**From:** Ella Bucklow [REDACTED] >  
**Sent:** 09 June 2020 18:08  
**To:** Gregory, Michele <MICHELE.GREGORY@planninginspectorate.gov.uk>; A1 Birtley to Coal House <SM-A1BirtleytoCoalHouse@planninginspectorate.gov.uk>  
**Cc:** Antony Gormley [REDACTED]; Alice O'Reilly <[REDACTED]>; Bryony McLennan <[REDACTED]>  
**Subject:** FW: A1 Birtley to Coal House - ExA's third Written Questions

Please find below the responses to the Examiner's Third Written Questions on behalf of Sir Antony Gormley and Antony Gormley Studio 20023052 / 20023053:

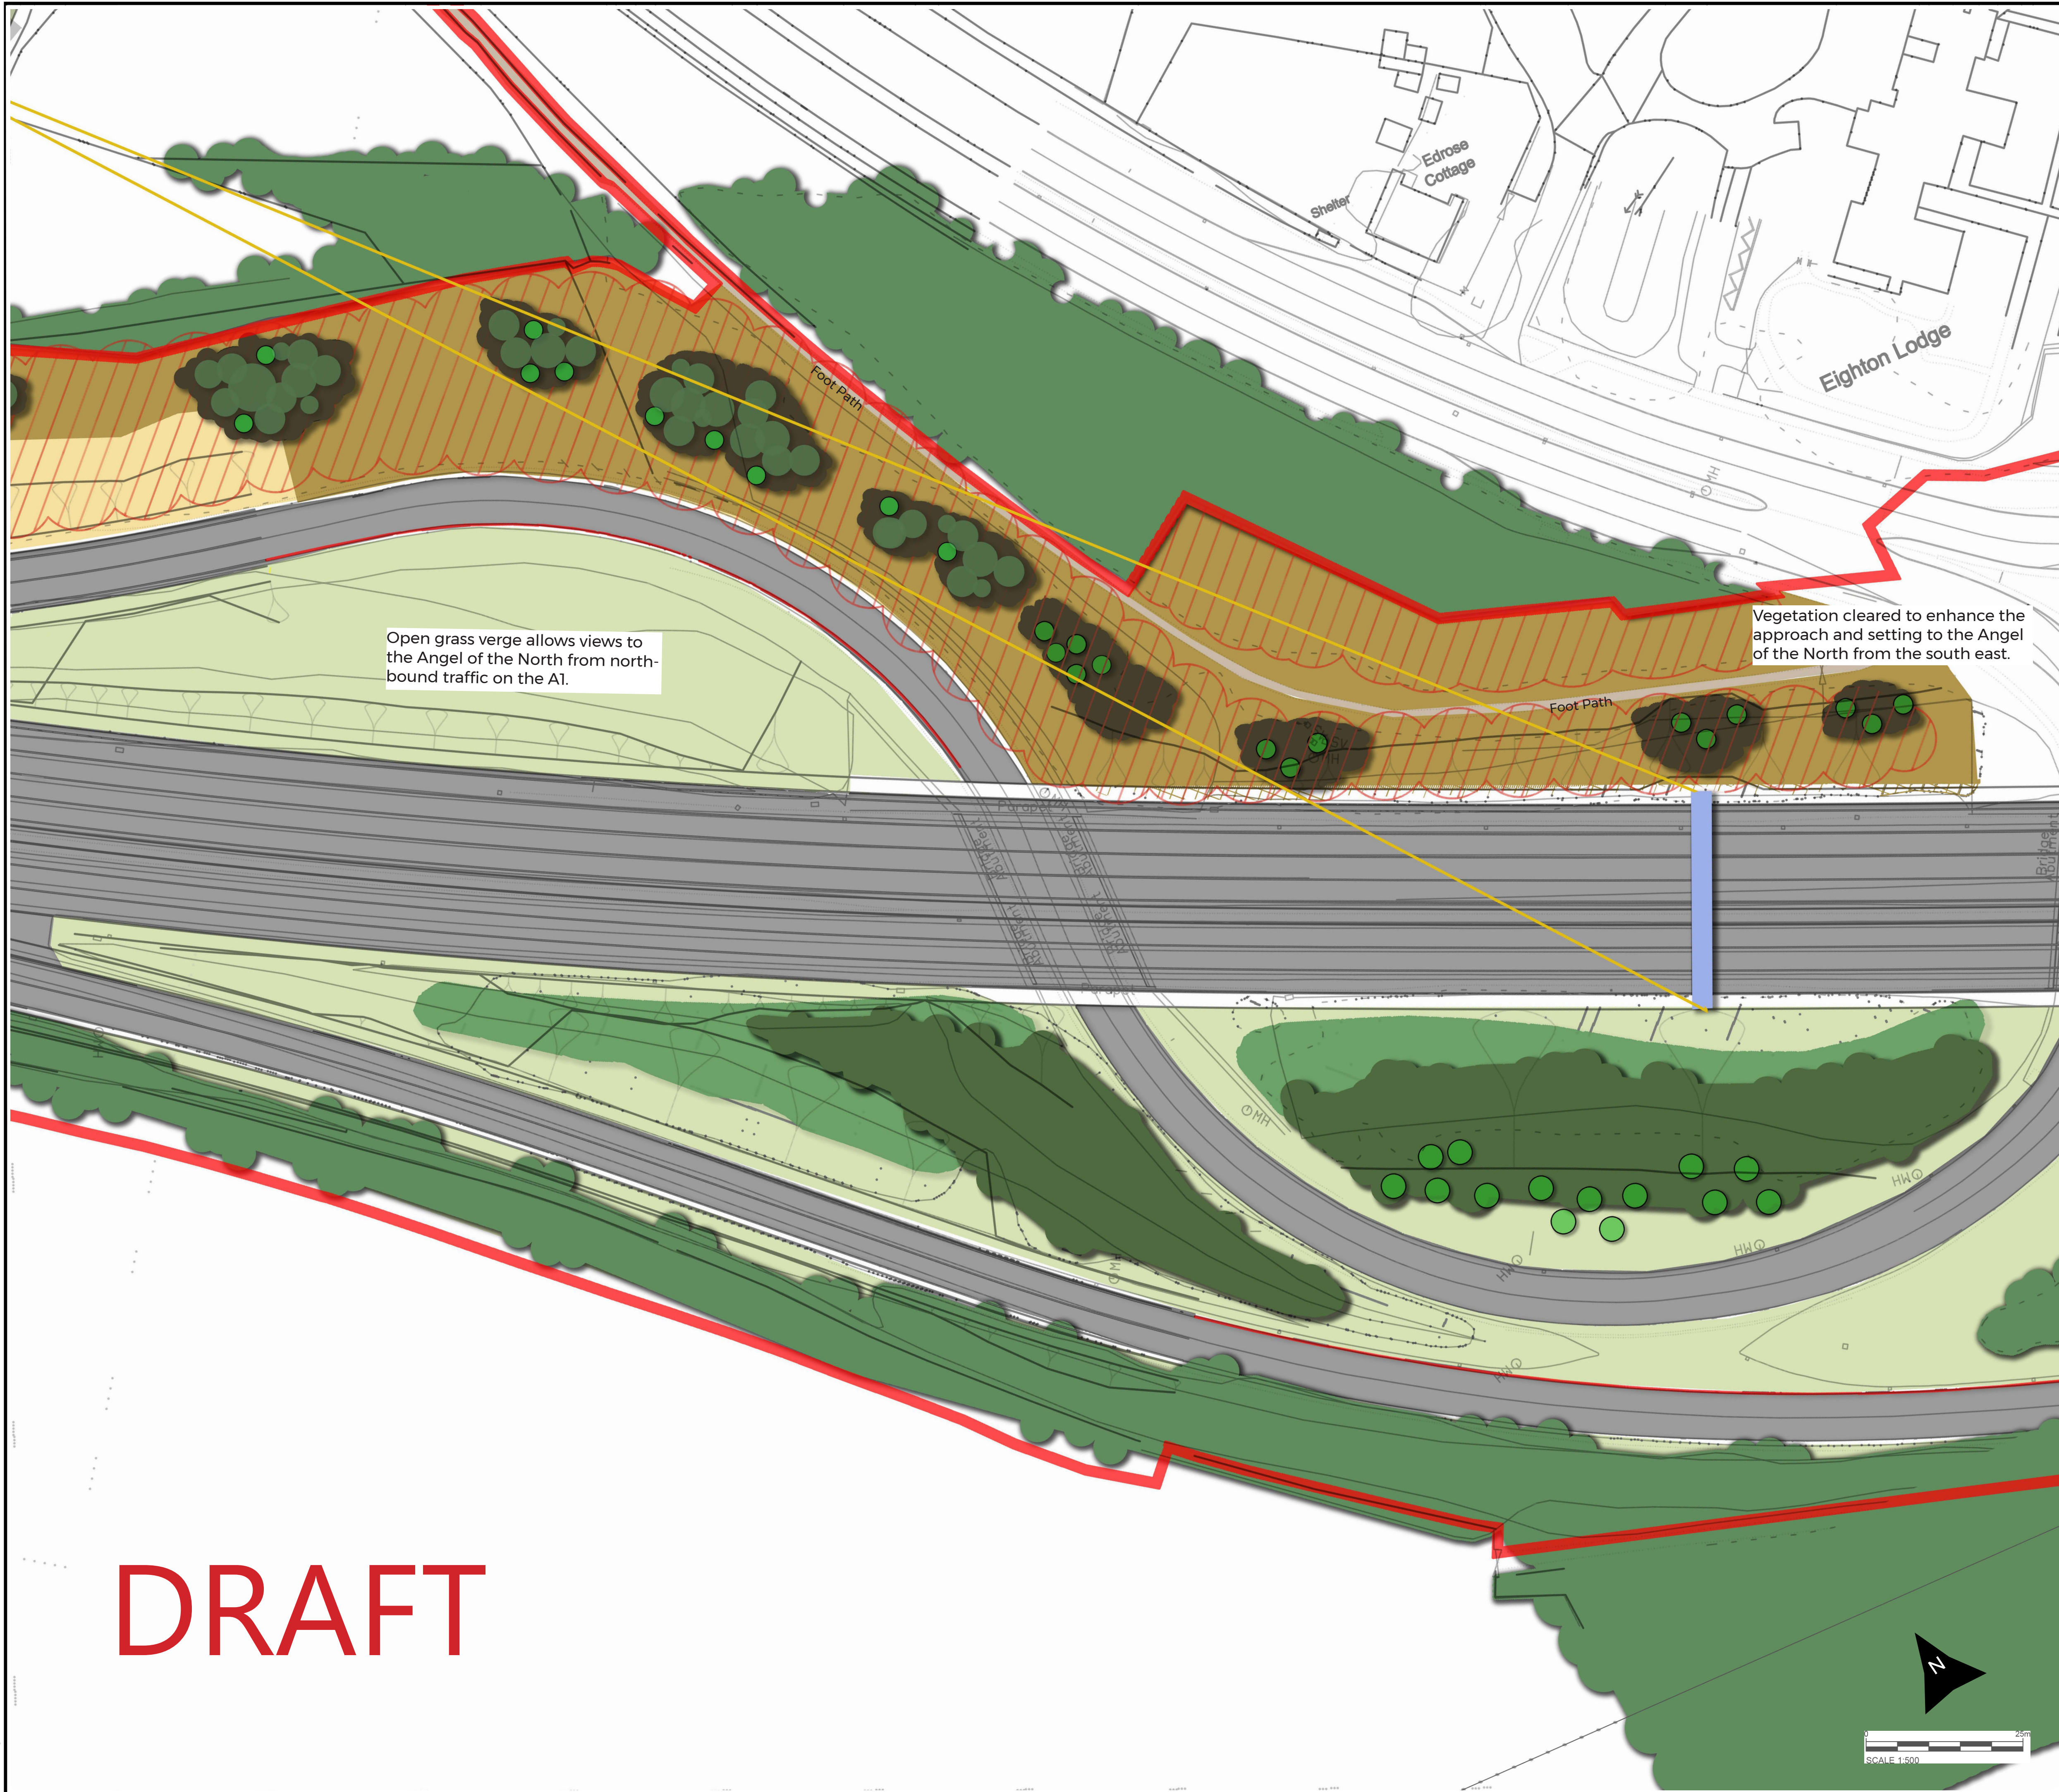
As per our response to the Examiner's Third Written Questions we would like to remain in consultation as the placement and design of the gantries are finalised.  
To reiterate, the open truss design is our preferred option.

‘Option 3: Revealing the Angel’ remains our preferred scheme.
